RE: Response to Request for Information, Bays 1-4a of the Locomotive Workshop, South Eveleigh (SSD 8517, MOD 7)

Ethos Urban has prepared this letter on behalf of Mirvac Projects Pty Ltd (Mirvac) in response to the Department's Request for Additional Information dated 16 February 2021, which related to the Modification Application (MOD 7) to amend State Significant Development (SSD) Consent SSD 8517 for the adaptive reuse of Bays 1-4a of the Locomotive Workshop and Innovation Plaza at South Eveleigh.

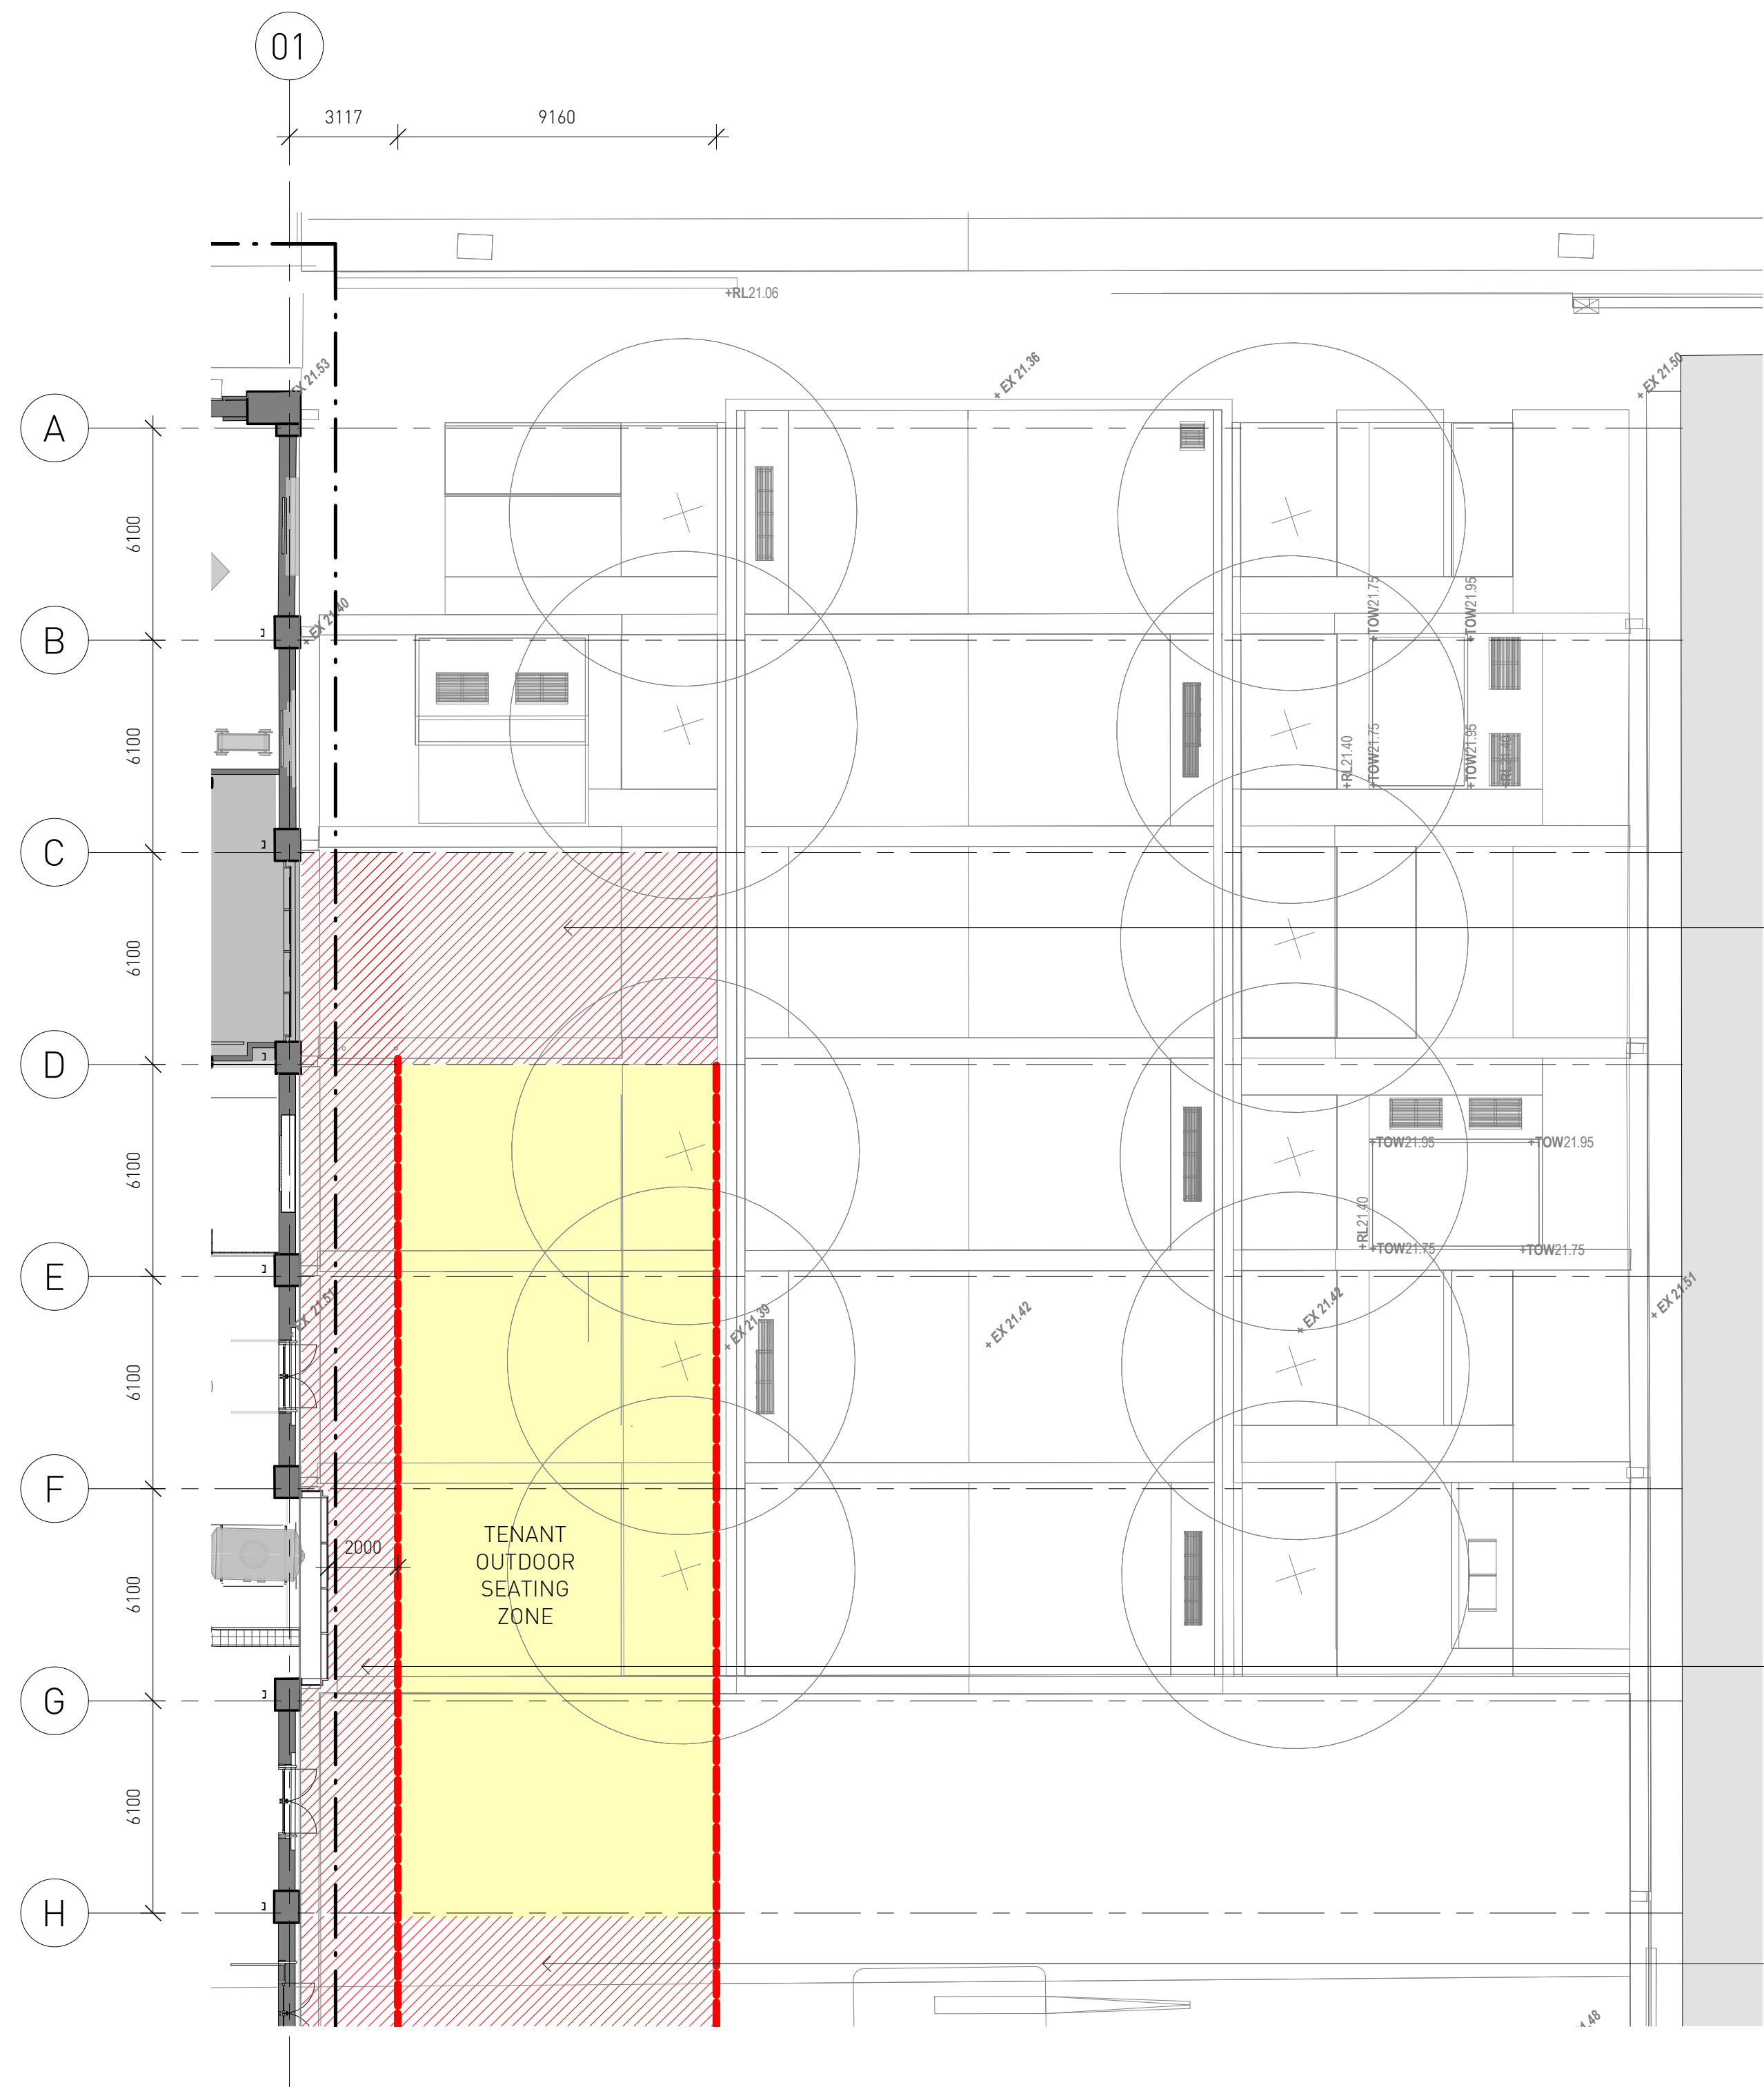
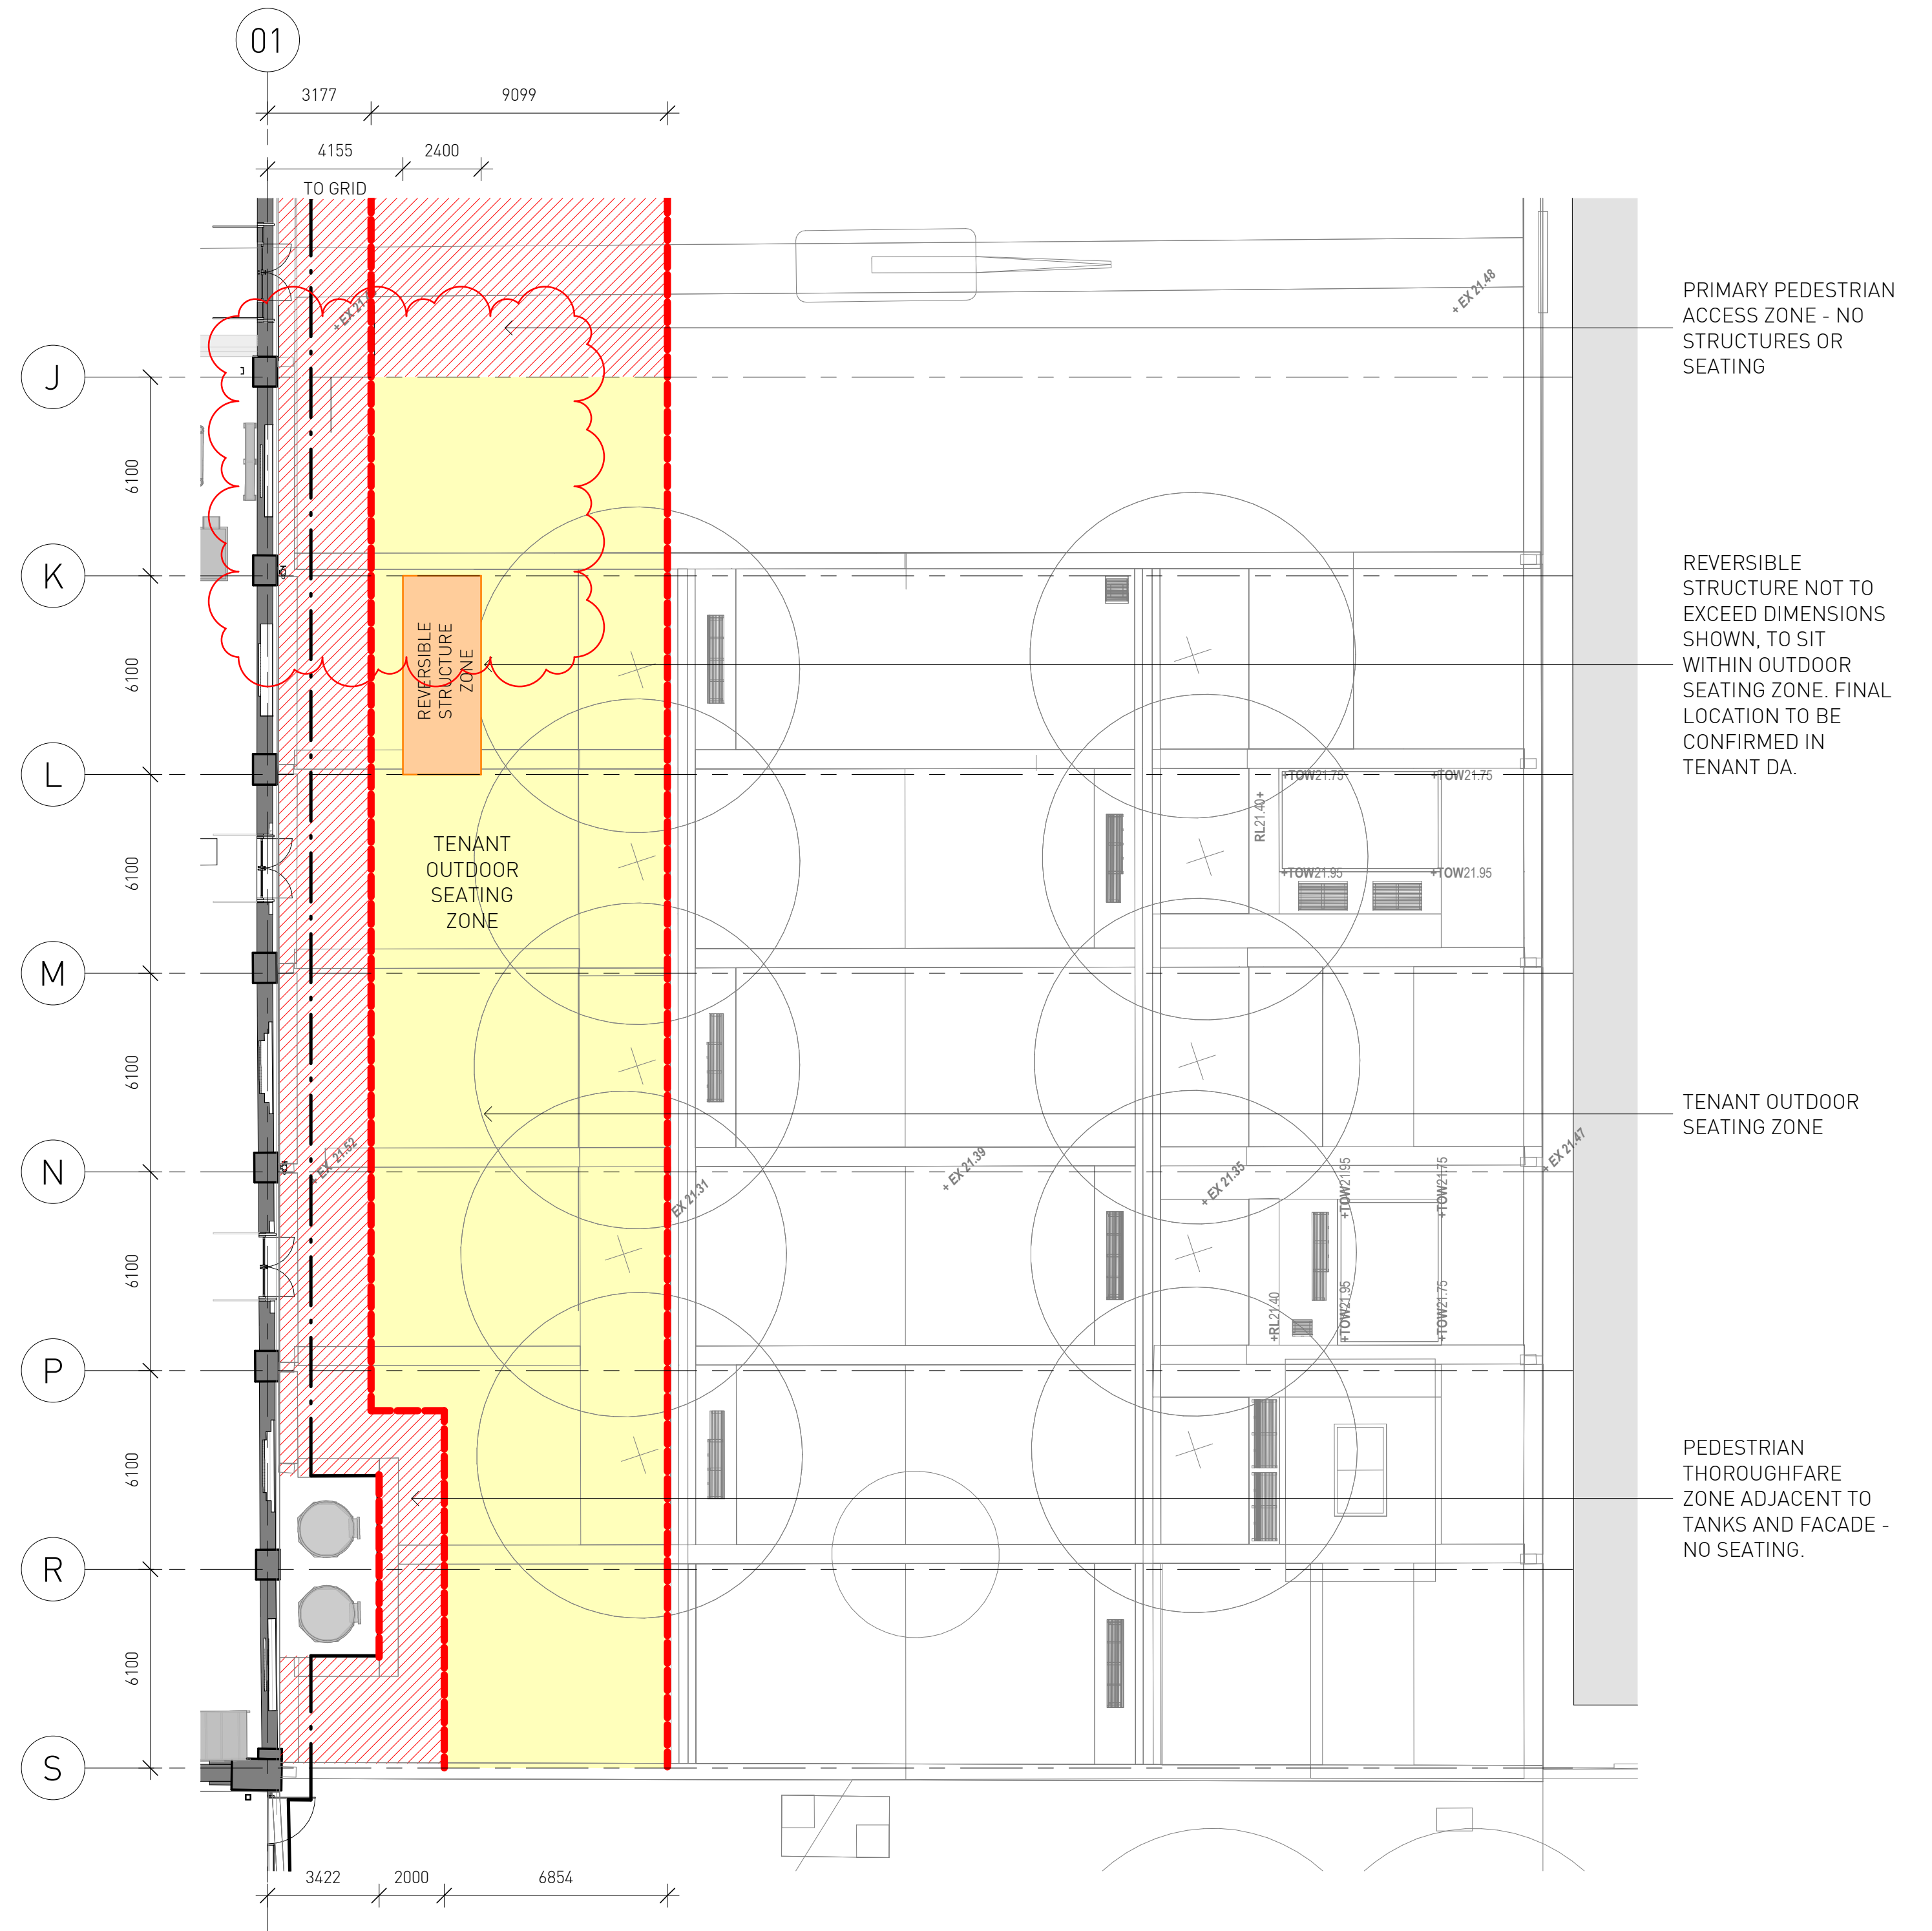
It is recommended that the proposed building envelopes be reconsidered, noting the public recreation zoning, heritage values of Innovation Plaza and the concerns raised by Heritage NSW and Council about the introduction of permanent built structures within Innovation Plaza.

While the Department is open to considering options for activation of Innovation Plaza, consideration should be given to flexible and non-permanent alternatives, developed in consultation with heritage NSW and Council.

Options should be explored to increase the width of the continuous path of travel between the Locomotive Workshop and outdoor seating zones, to improve pedestrian movement and provide appropriate separation between the outdoor seating area and the Locomotive Workshop.

The revised Architectural Plans included at **Attachment A** and in **Figures 2 and 4** below demonstrate that only one structure zone is now proposed, and the awning structure zone has been removed. It is still intended to provide a bar within the structure zone from which drinks will be served and as such it will be permanently placed in the proposed location, whilst the tenancy is operational. However, the proposed composition is likely to be a container-like structure which will be fully reversible in nature and can easily be removed without leaving any permanent physical or visible traces of it being there, as depicted in **Figure 5**.

As illustrated in the revised architectural plans and public domain plans (**Attachments A and B**), the continuous path of travel between the Locomotive Workshop and the outdoor seating zone has been increased by 1517mm from 1600mm to 3117mm, with the exception of the dogleg around the tanks in Innovation Plaza South.

DRAWING NO.
LOCOMOTIVE-SSDA-06-REV3

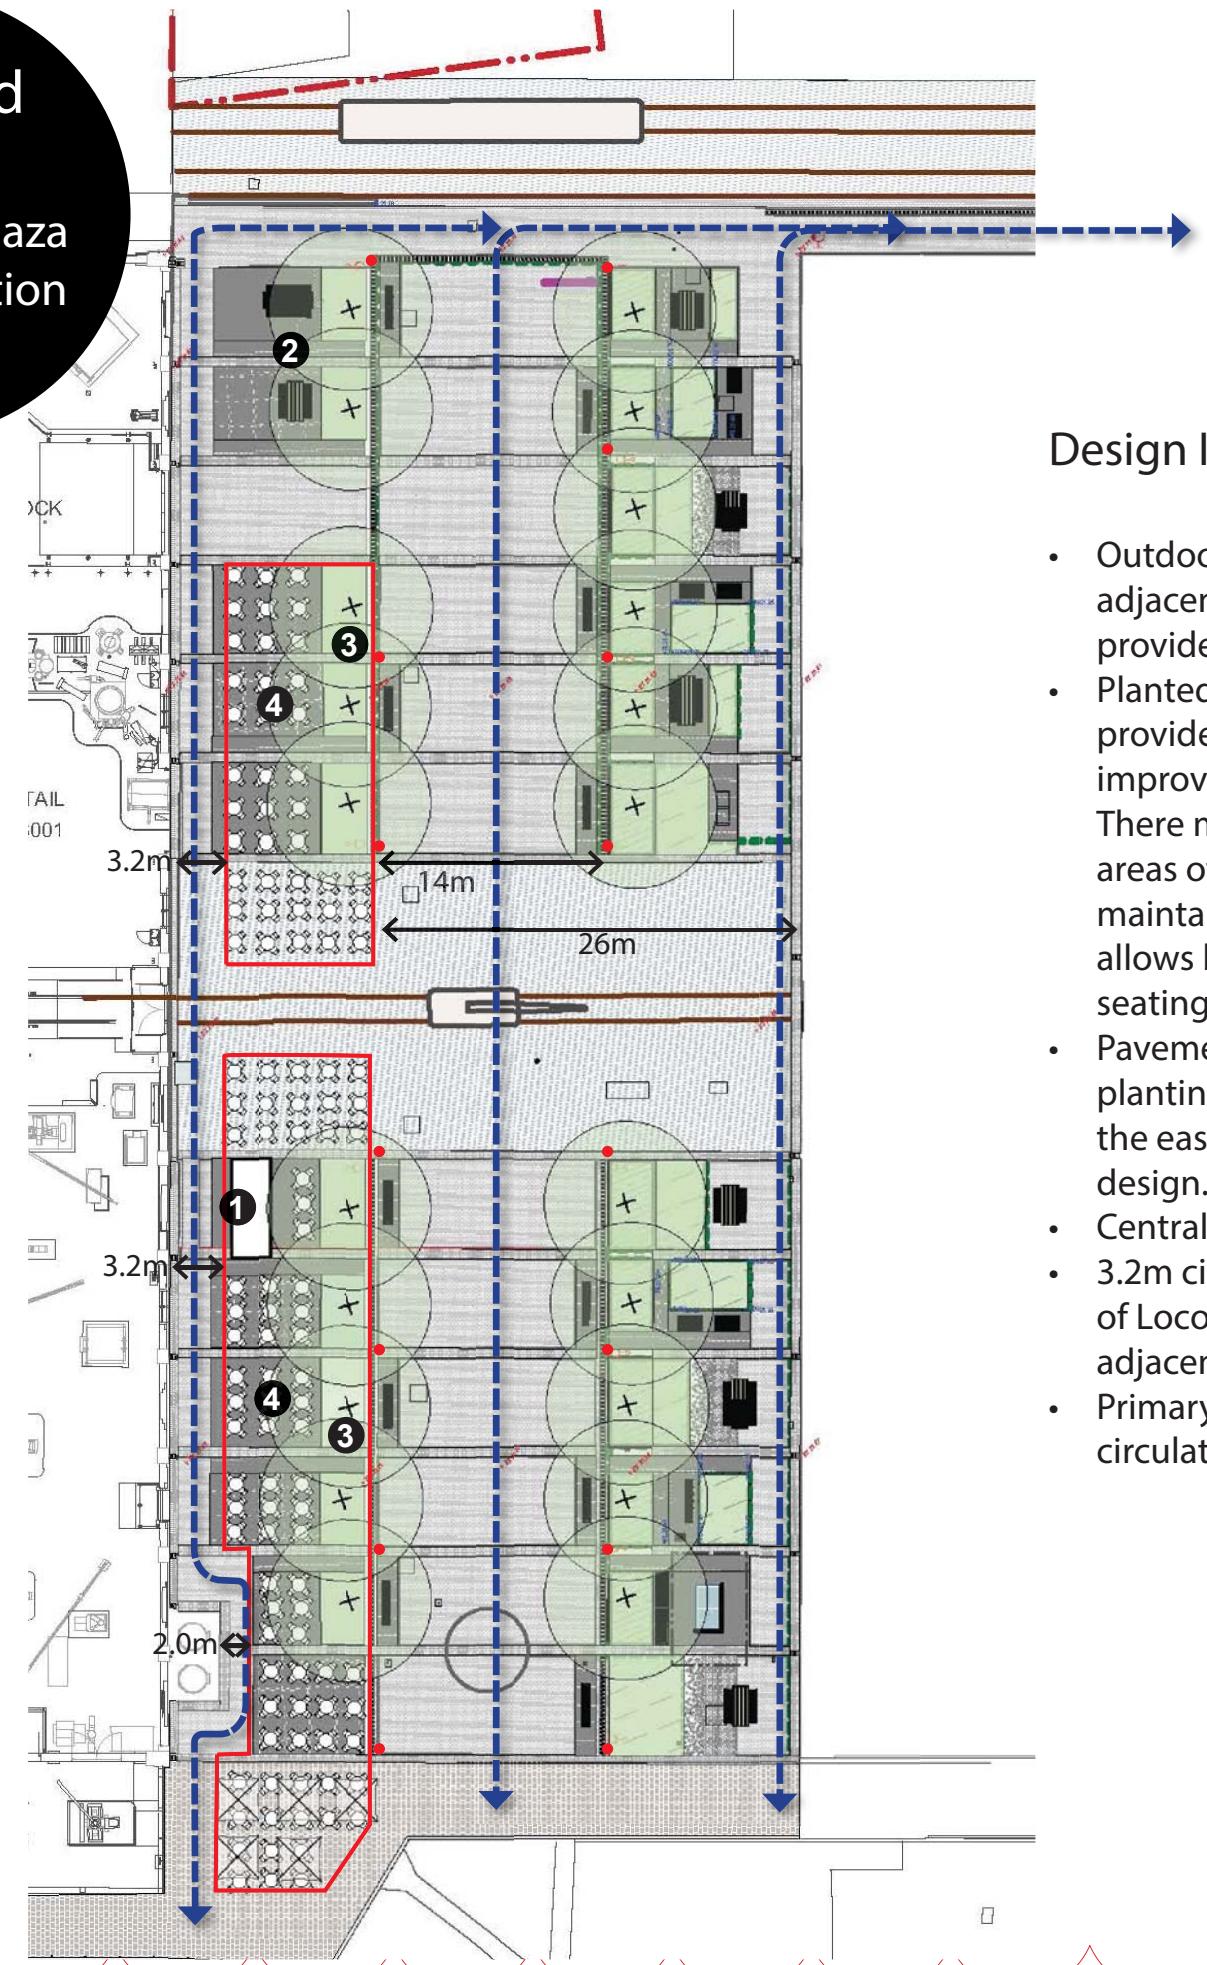
Update Public Domain Plan No.6 Rev 2 to ensure the outdoor seating zones do not extend over the path of travel and are consistent with the architectural plans submitted.

Noted, the public domain plans have been updated as included in **Attachment B**.
